The Sizewell C Project

9.10.27 Initial Statement of Common Ground - Minsmere Levels Stakeholder Group

Revision: 1.0
Applicable Regulation: Regulation 5(2)(q)
PINS Reference Number: EN010012

June 2021

DRAWING TITLE:
MAIN DEVELOPMENT SITE SSSI CROSSING
(UNDER CONSTRUCTION - BAILEY BRIDGE STAGE)

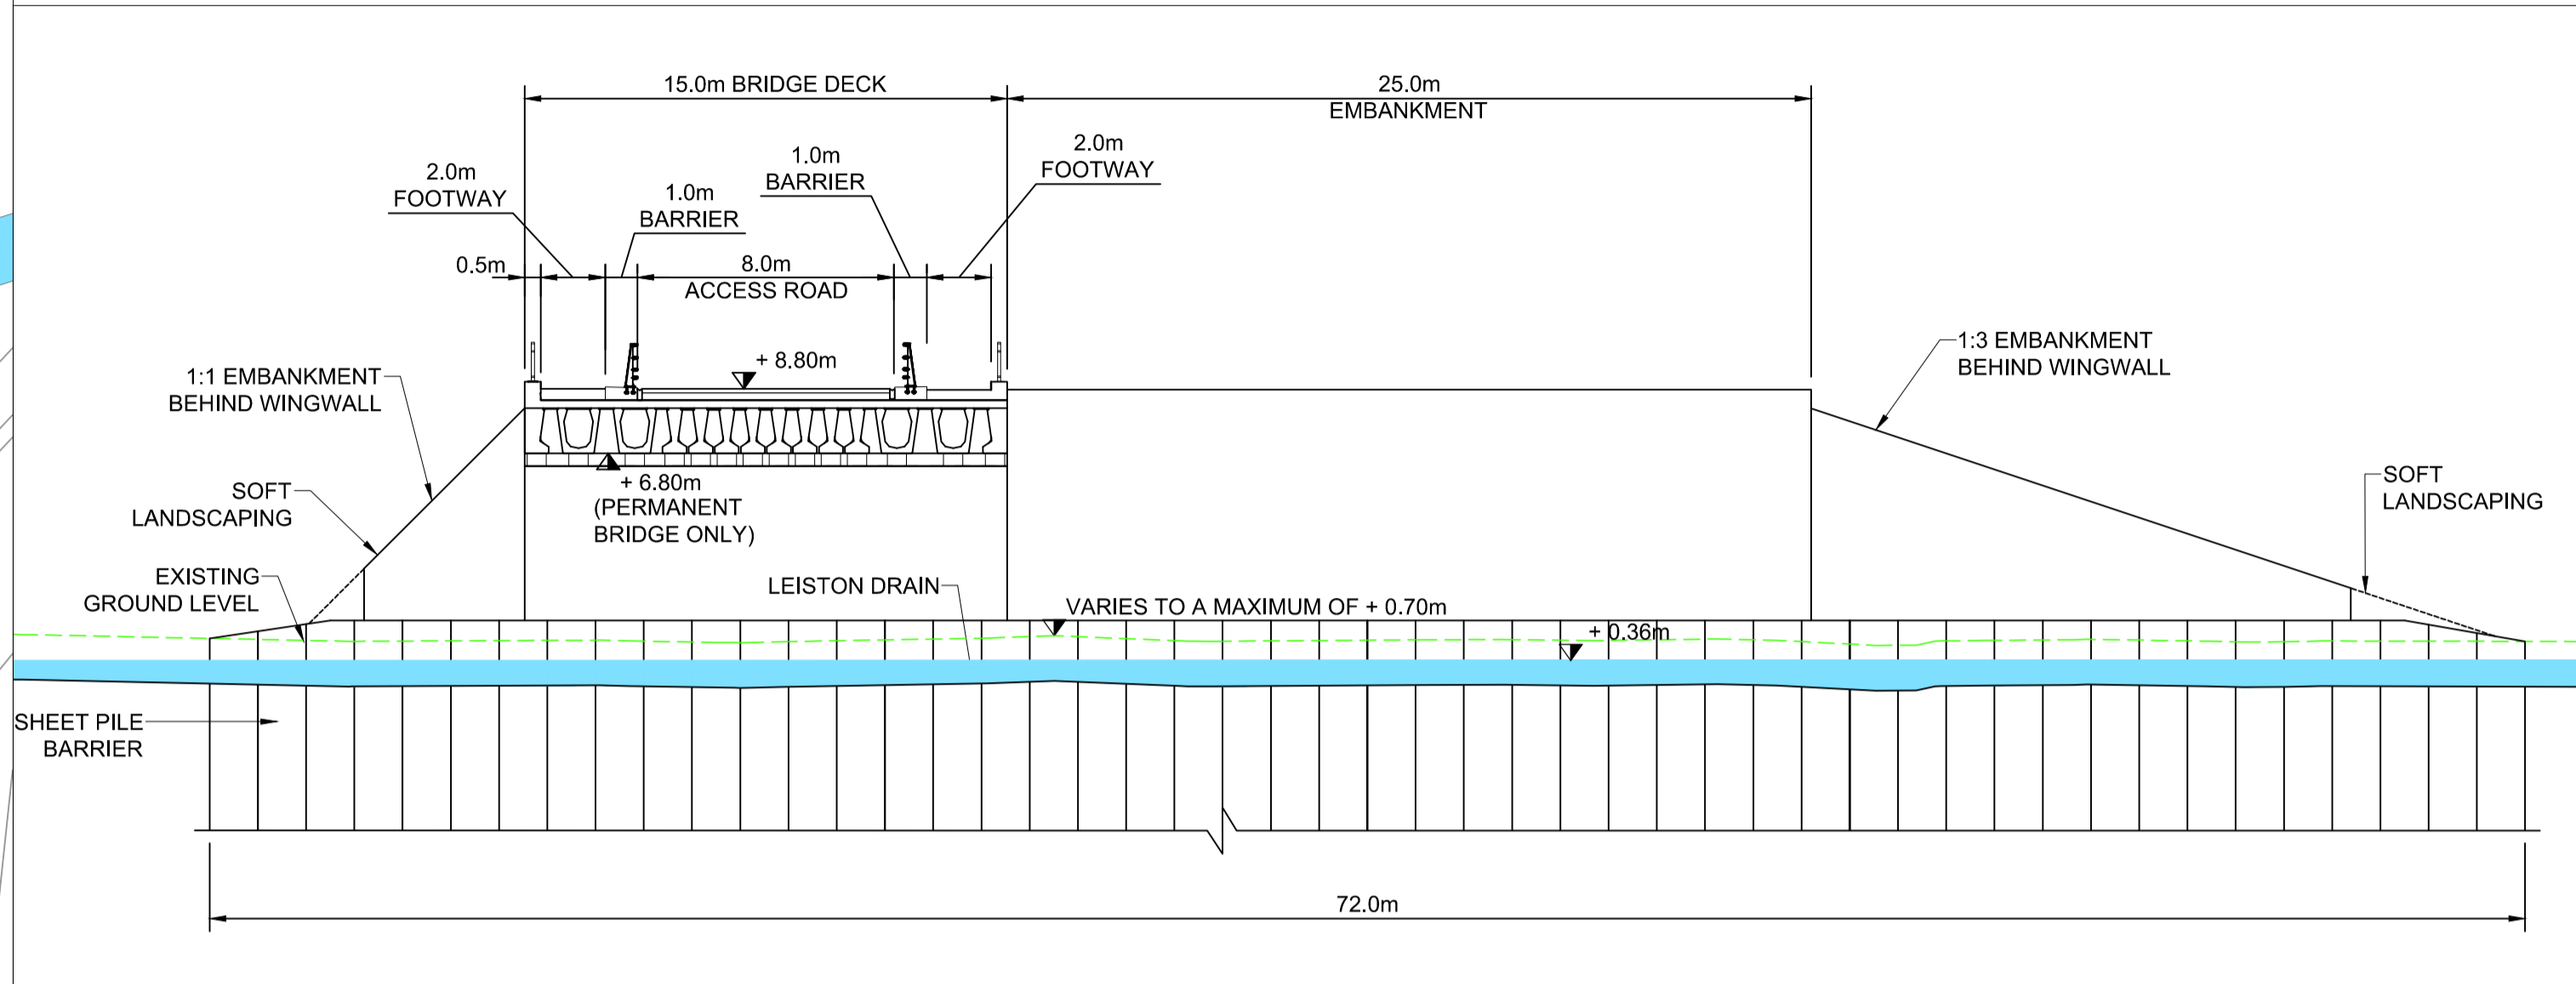
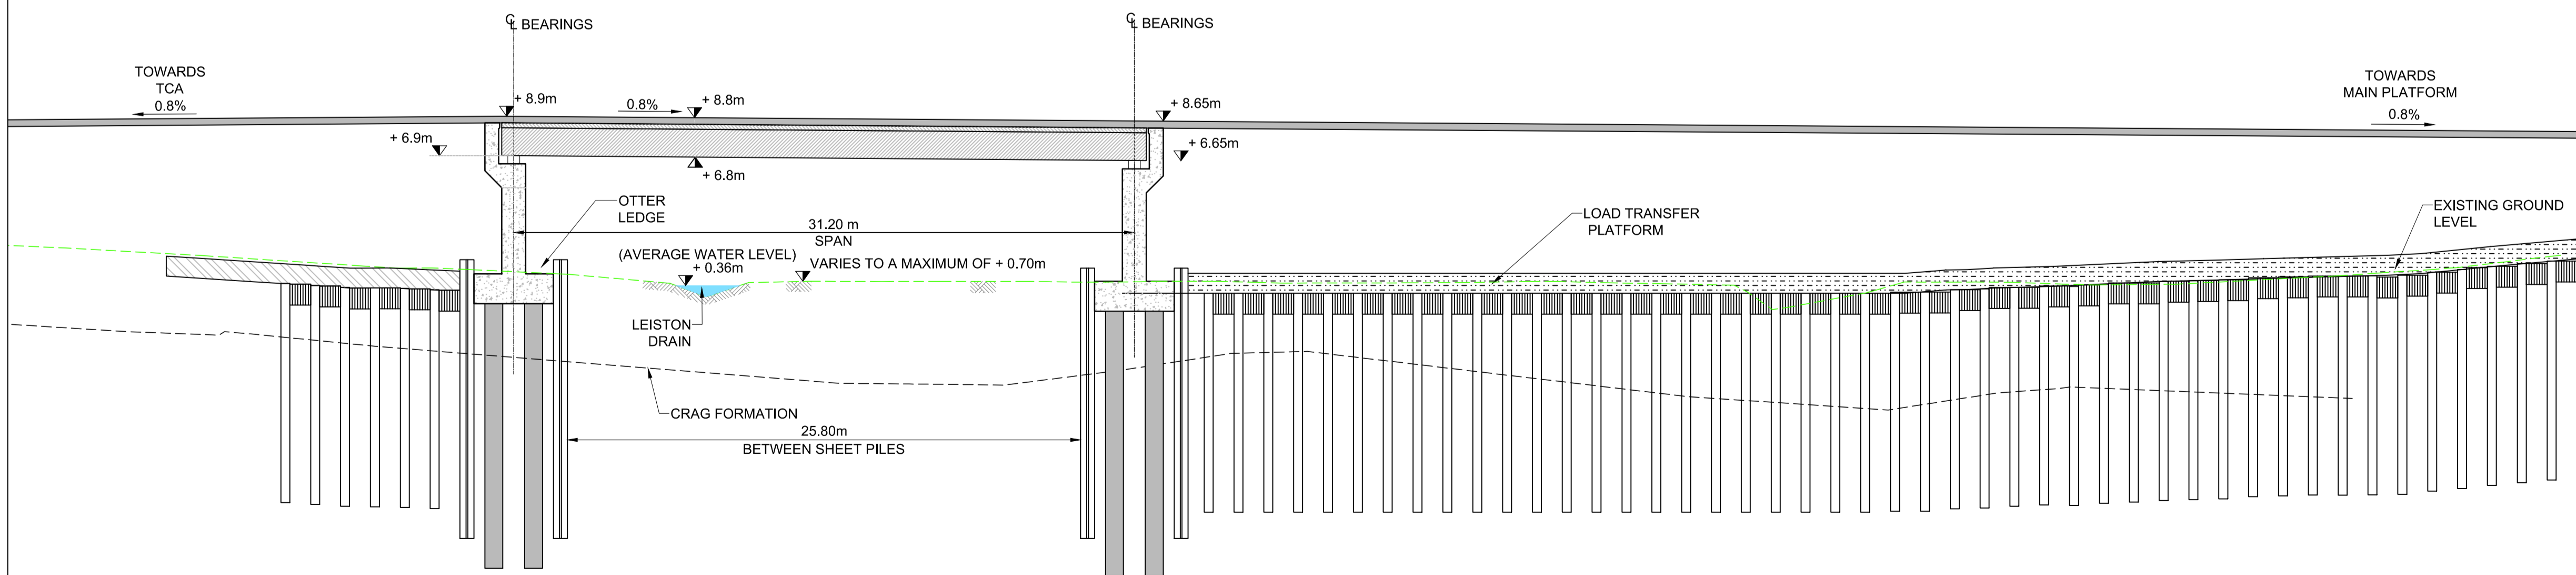
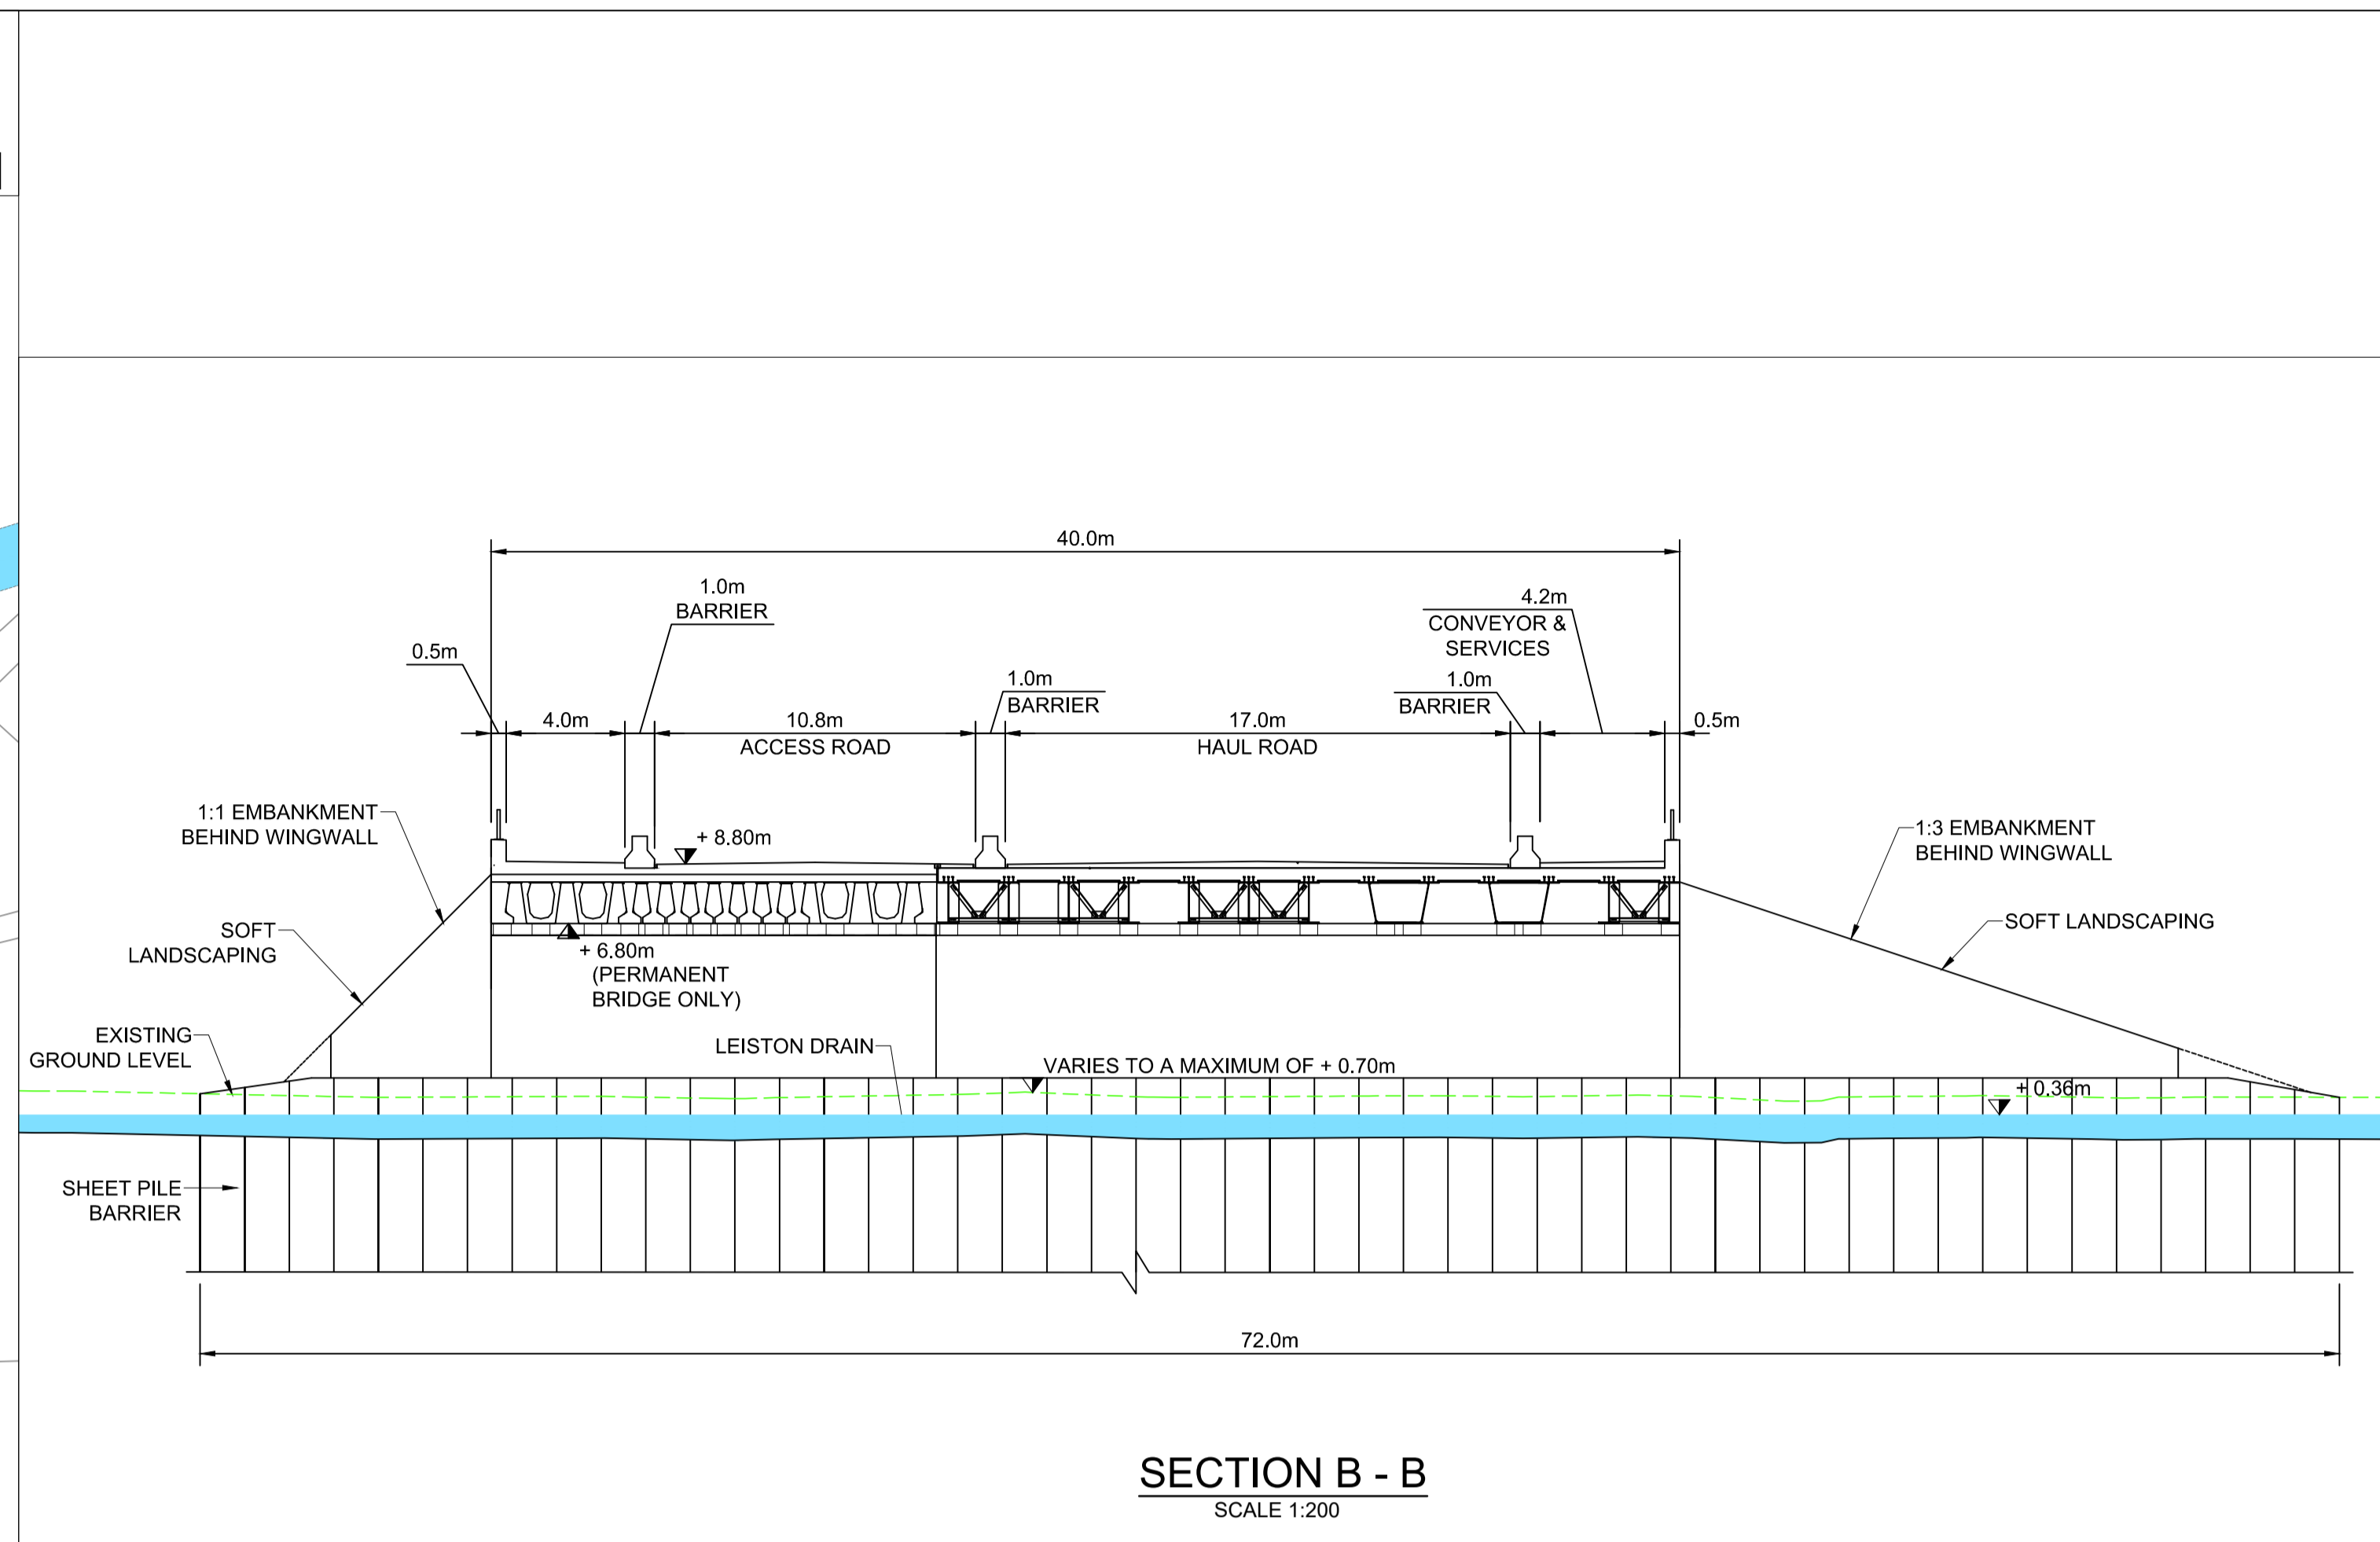
7	Impact of the SSSI Crossing	<p>RR: Hydrological impacts of the proposed Causeway and Culvert crossing are not properly assessed.</p> <p>The overall ecology of both Sizewell Marsh and Minsmere Levels are reliant on the annual cycle of ground and surface water changes, any disturbance will have direct impacts on bird, insect, reptile and mammal species.</p> <p>At 7th May: MLSG support the position of SCFOE, Suffolk Wildlife Trust (SWT) and RSPB as stated in the position of the parties.</p> <p>We support Environment Agency's (EA) position that the wider culvert proposal, now accepted in the changes to the DCO, still do not meet the need for an open construction, as proposed in earlier consultation options for a 3 span bridge structure and are concerned that long dark culvert will not satisfy the Water Framework Directive. Any significantly piled structure placed across the narrow gap between Sizewell Marsh and Minsmere Levels will have an impact on both ground and surface water quality and flows and we concur with EA and SCFOE that the structure as proposed is unacceptable.</p> <p>The proposals to replace coastal fenland with fen meadow only is misplaced because the habitats being destroyed are a matrix of other habitat types that together also enable the exceptional SSSI special interest feature (invertebrates) to exist. This appears to have been overlooked. All proposed sites for fen</p>	<p>The original design of the SSSI Crossing culvert had been oversized to minimize effects on natural hydrologic function. However, flood risk modelling showed that during extreme events the culvert could impede the flow of flood waters, albeit with very small effects on flood levels. The proposed widened bridge design further limits the impact on hydrology, and also on flood flows. Consequently, the impact of flood levels is further reduced and the effect from the revised SSSI Crossing is substantially mitigated, both for the development and off-site receptors.</p> <p>Further details are set out in the ES Addendum (Doc Ref 6.14), Main Development Site Flood Risk Assessment Addendum (Doc Ref. 5.2(A)Ad) and Outline Drainage Strategy (Doc Ref. 6.3) [APP-181].</p> <p>As noted above, the degree of change in water level is not expected to have significant adverse effect on the habitats within the Sizewell Marshes SSSI.</p> <p>Sizewell Drain would be diverted north, parallel to the base of the platform slope, provided in Appendix 19C of the ES. At its northern extent, it would discharge to the Leiston Drain upstream of the SSSI crossing. In addition, revised water level management may be required for the drainage units and watercourses adjacent to the construction site. This would require the inclusion of a water level control structure along the realigned Sizewell Drain. This structure would allow for fine tuning of water levels. The control structure will act to prevent any detrimental impacts on groundwater from the Sizewell Drain. The specific position, nature and operational parameters of the control structure will be determined in conjunction with</p>	<p>SZC's Position</p> <p>Not agreed. However, a meeting can be arranged by the Applicant to discuss opportunities for narrowing the area of disagreement between us on this topic.</p> <p>MLSG's Position.</p> <p>Not agreed. Whilst a meeting has been offered, at this time we decided to respond electronically and may request a meeting at a future date.</p>

Ref.	Matter	MLSG's position [Starting from relevant representation (RR)]	SZC Co.'s Position	Position of the parties
			single span bridge design to identify opportunities to further reduce impacts on the SSSI. This work is ongoing but we are confident that at the end of construction the width of the single span bridge can be reduced from 40m to approximately 15m. It will also be possible to increase the soffit level although the design review has not yet concluded in this respect. Details of the optimised design are to be provided at Deadline 4.
